MIKE CAUSEY
INSURANCE COMMISSIONER

BRIAN TAYLOR
STATE FIRE MARSHAL

January 21, 2026

**RE: Flatwoods Middle School – Fire Sprinkler
Lillington, NC – Harnett County**

SITE PLAN

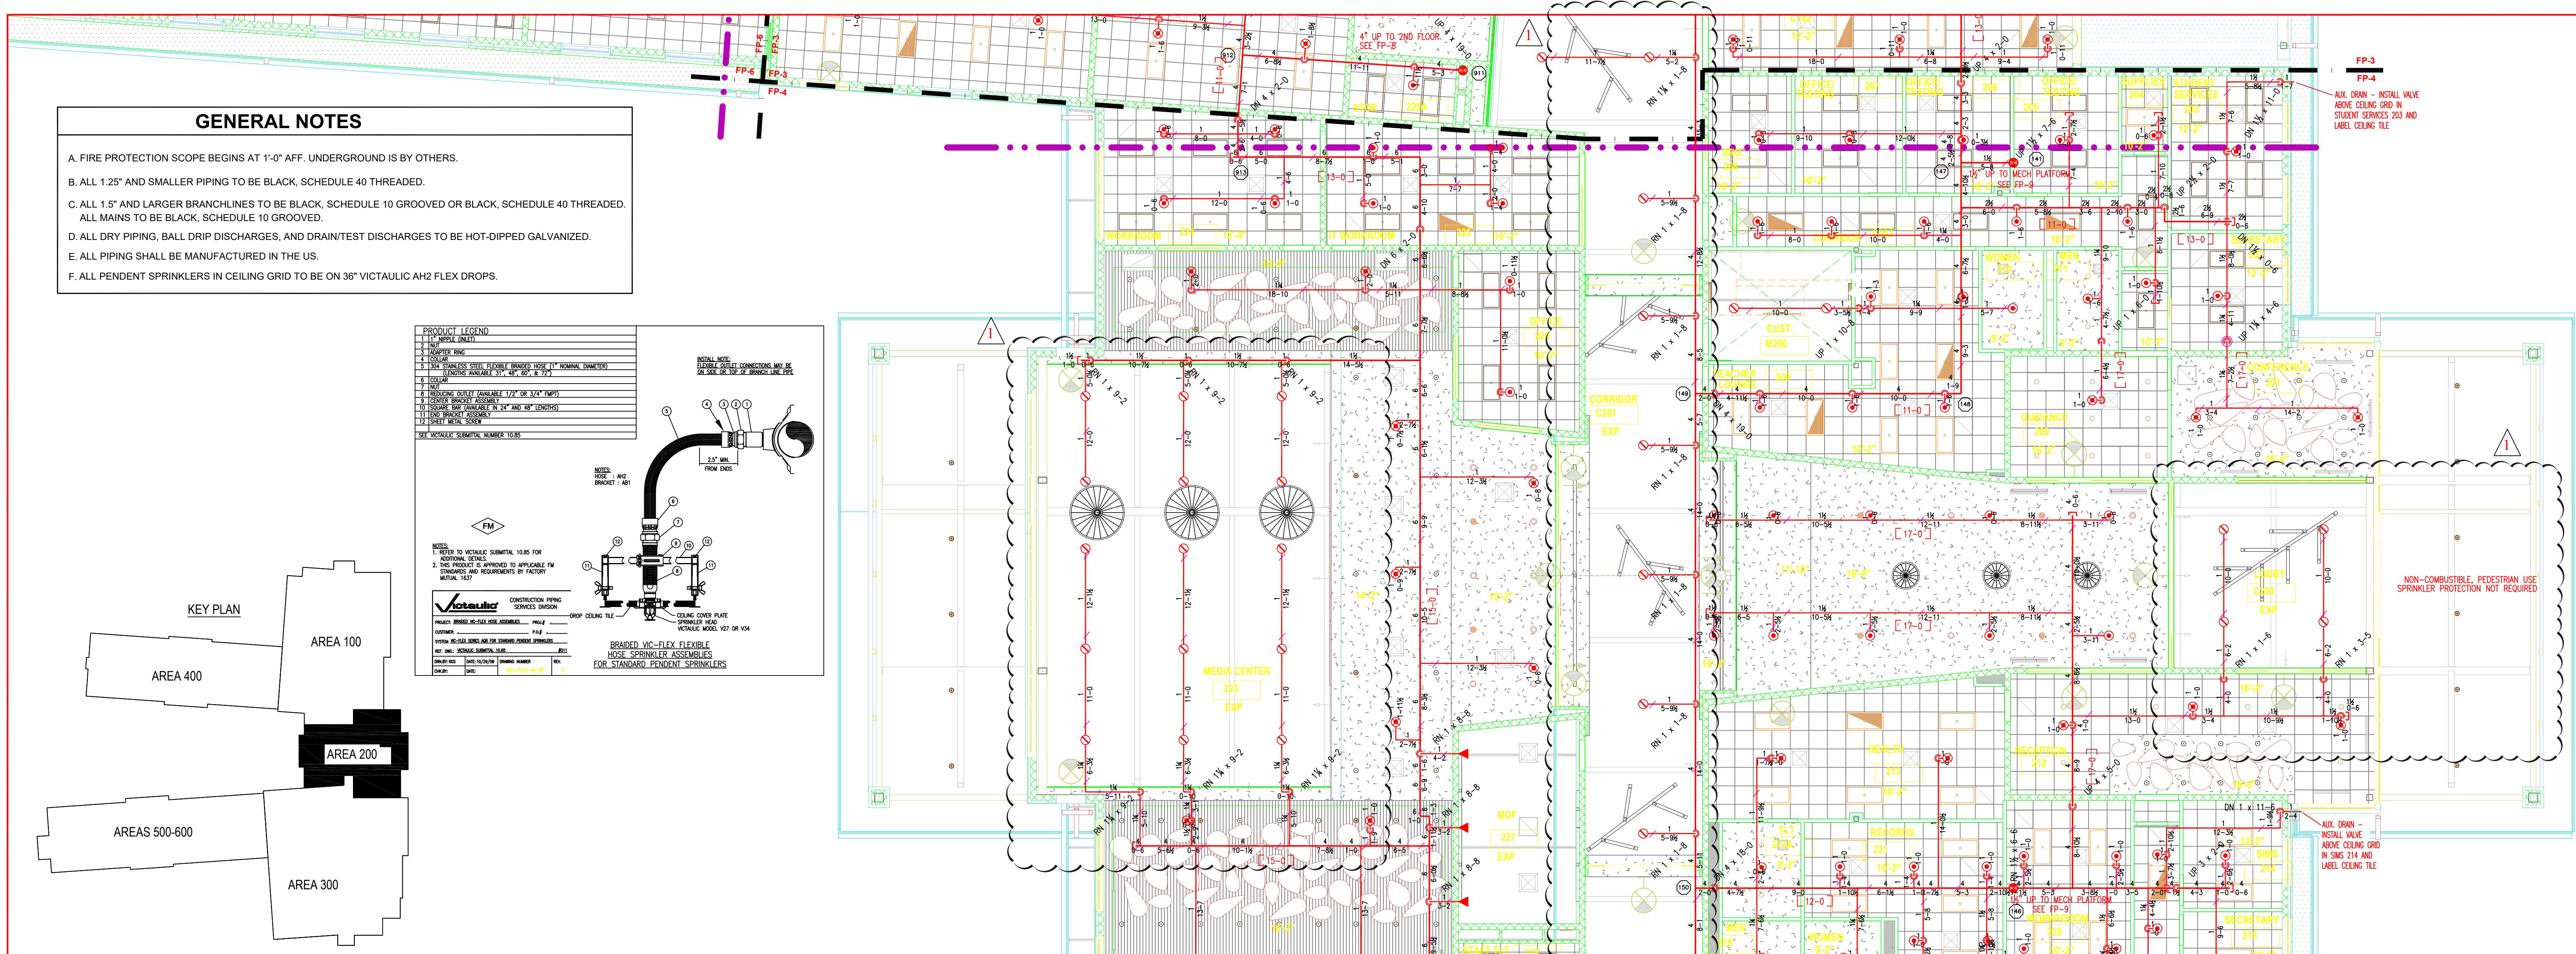
3. Provide material and weights with regard to point of connection to city main, types and locations of valves, valve indicators, regulators, meters, and valve pits, and the depth that the top of the pipe is laid below grade.

4. Provide provisions for flushing the underground private main.
5. Provide size and location of fire hydrants, showing size and number of outlets. Static and residual hydrants were used shall be shown that were used in water flow test.
